Subject: Objection to Planning Application [Application Number 2024/93492]

I am writing to formally object to the proposed planning application for a sun terrace and loft conversion at [86 Huddersfield Road Skelmanthorpe HD89AS]. As a close neighbour, I believe the approval of this project would have a significant and detrimental impact on my privacy and ability to use my property.

Drg. no.	Rev.
280-24-PL02	B

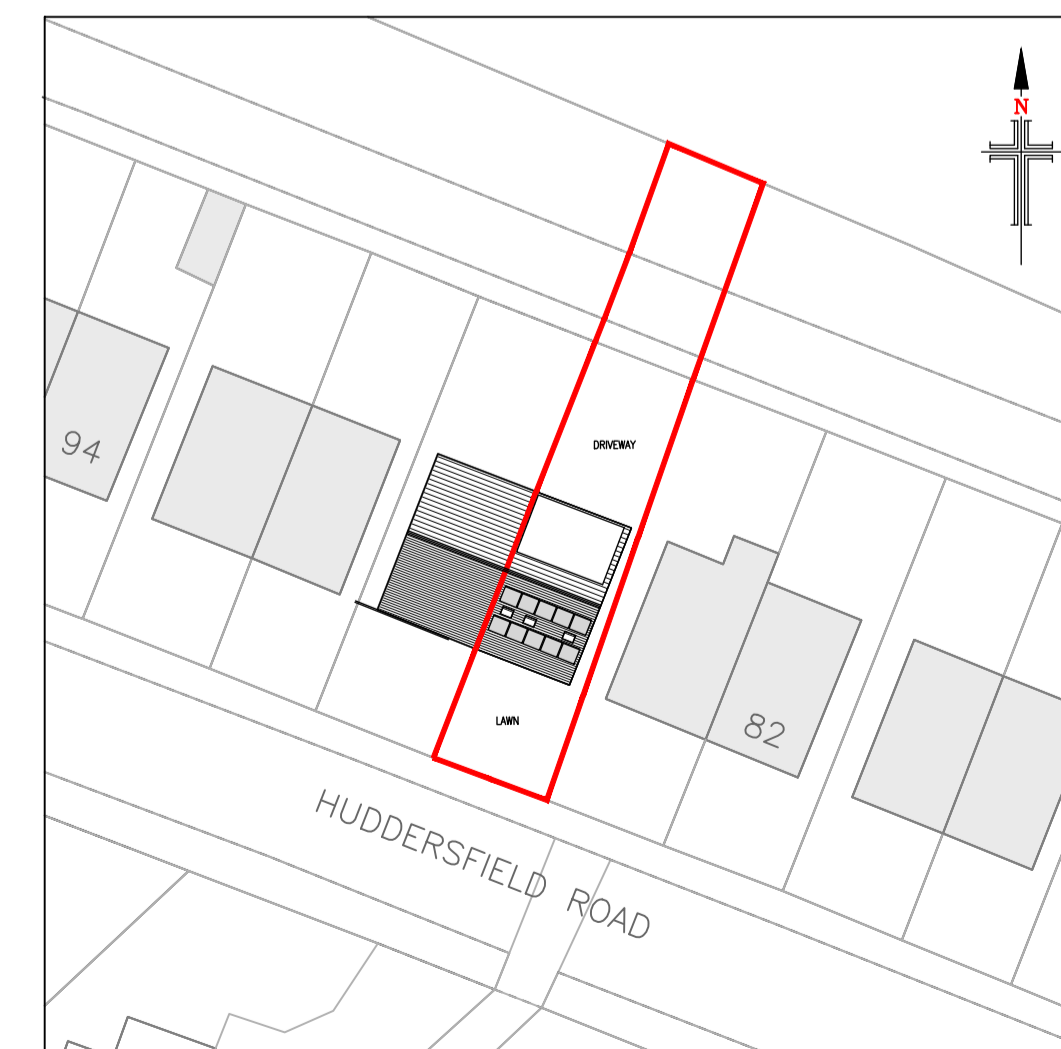
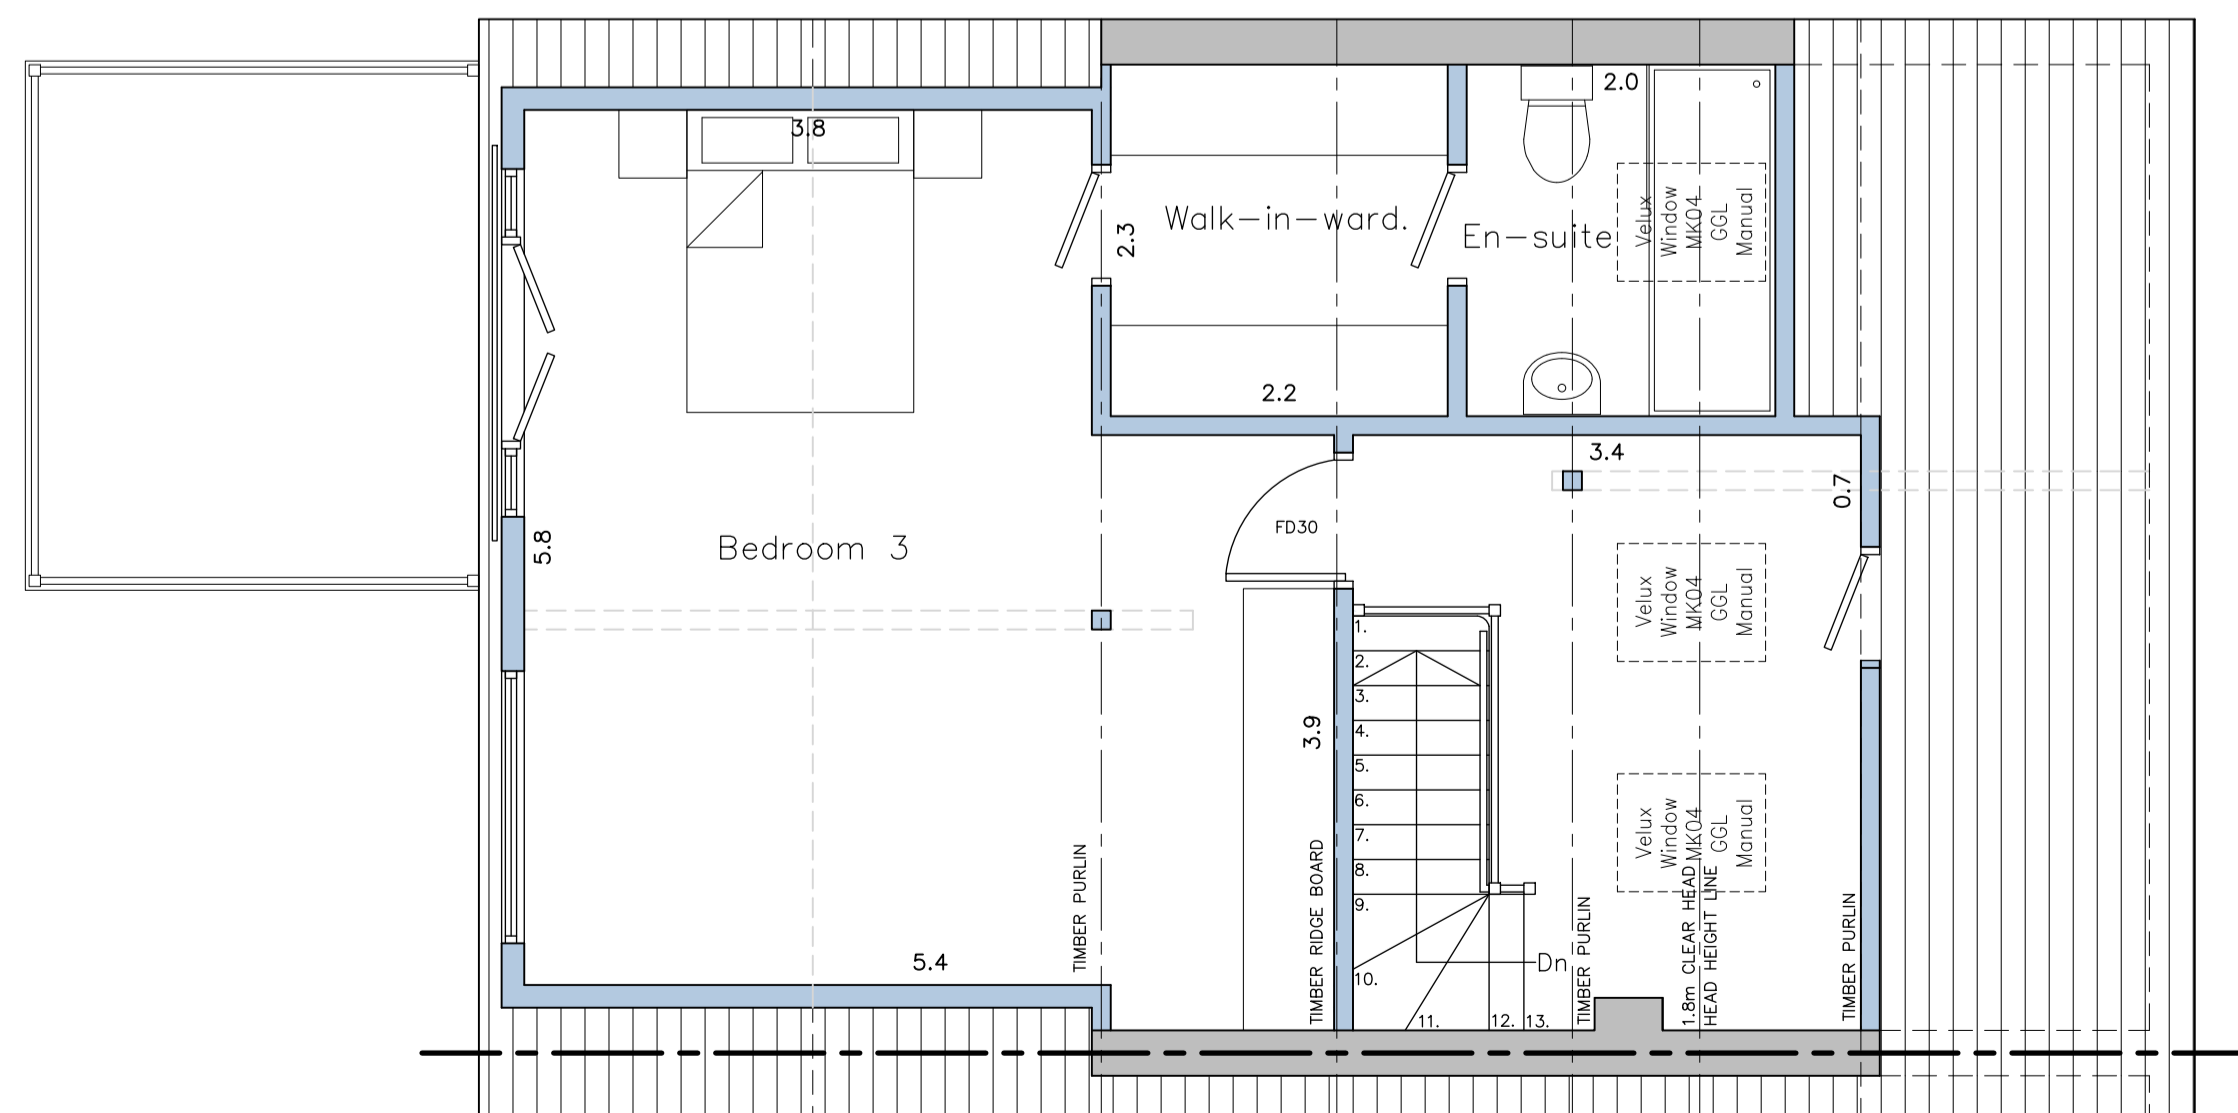
The proposed sun terrace is situated in such close proximity to my own terrace that it would directly overlook my outdoor space, completely invading my privacy. The elevation and placement of the terrace would give the occupants an unrestricted view of my terrace, making it impossible for me to enjoy this area of my property as I currently do.

Drg. no.	Rev.
280-24-PL03	B

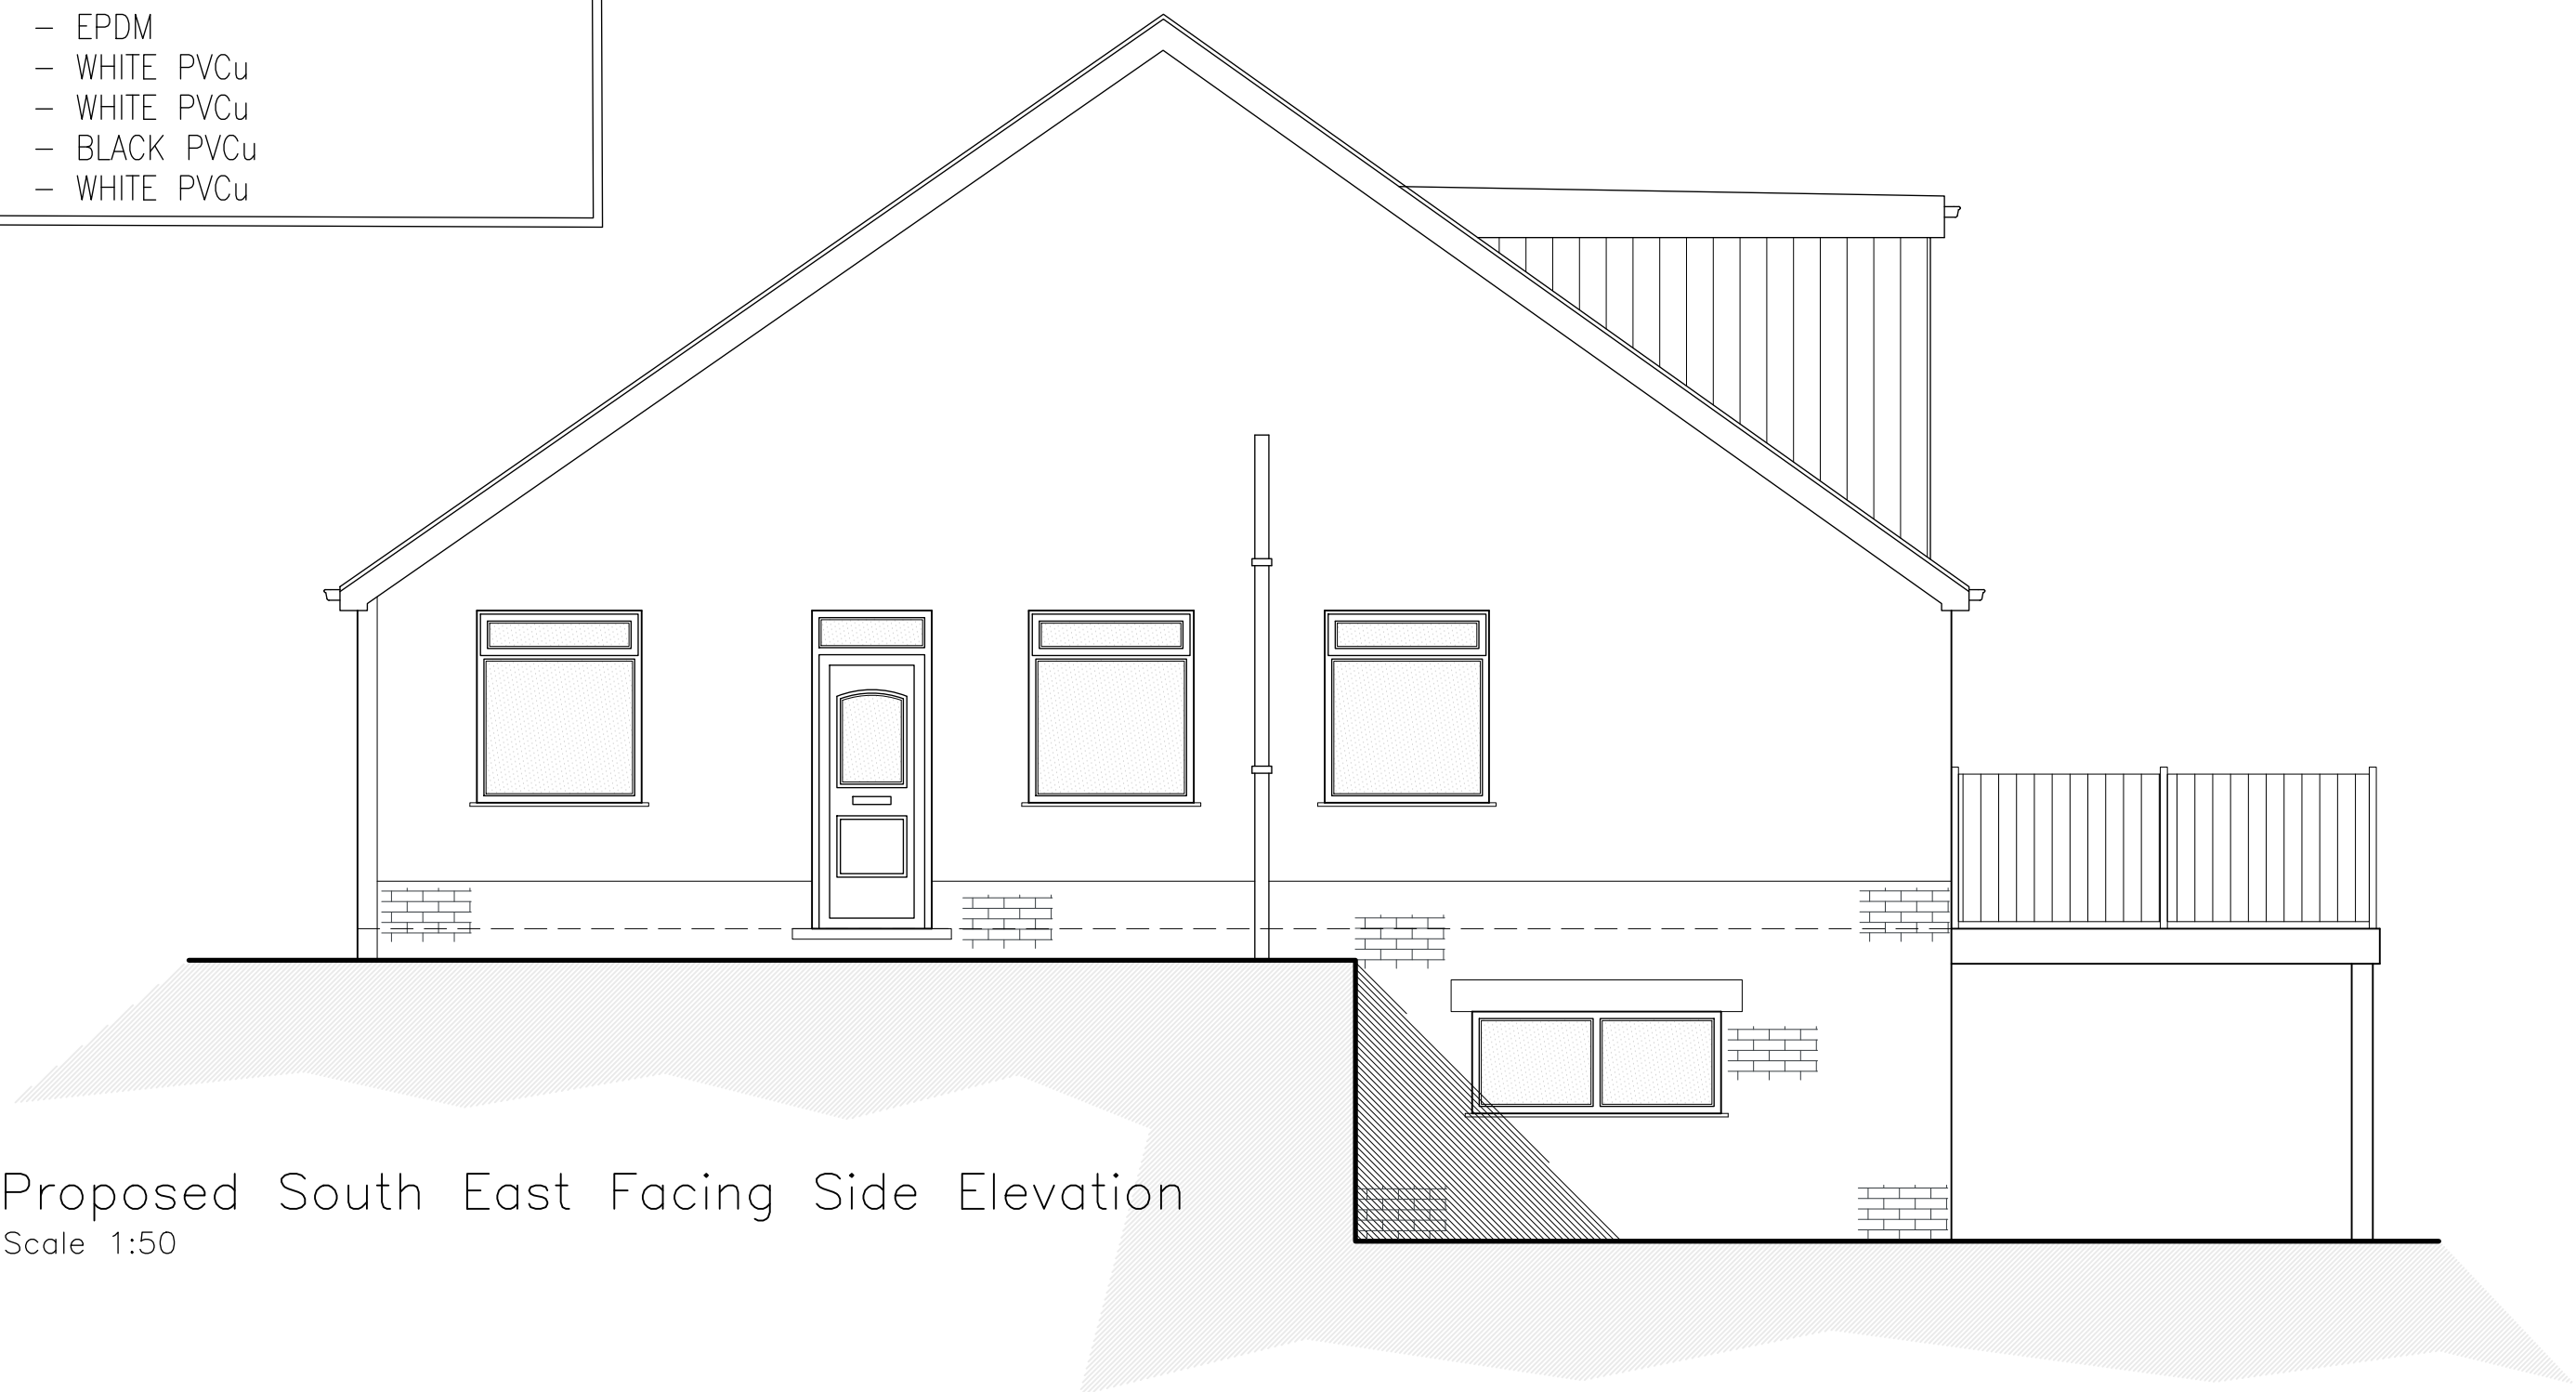
Additionally, the loft conversion door opening will create an overhead view that directly looks down onto my terrace. This would further compromise my privacy, leaving my outdoor space exposed and effectively unusable. These changes will significantly alter the character and enjoyment of my home and outdoor living area.
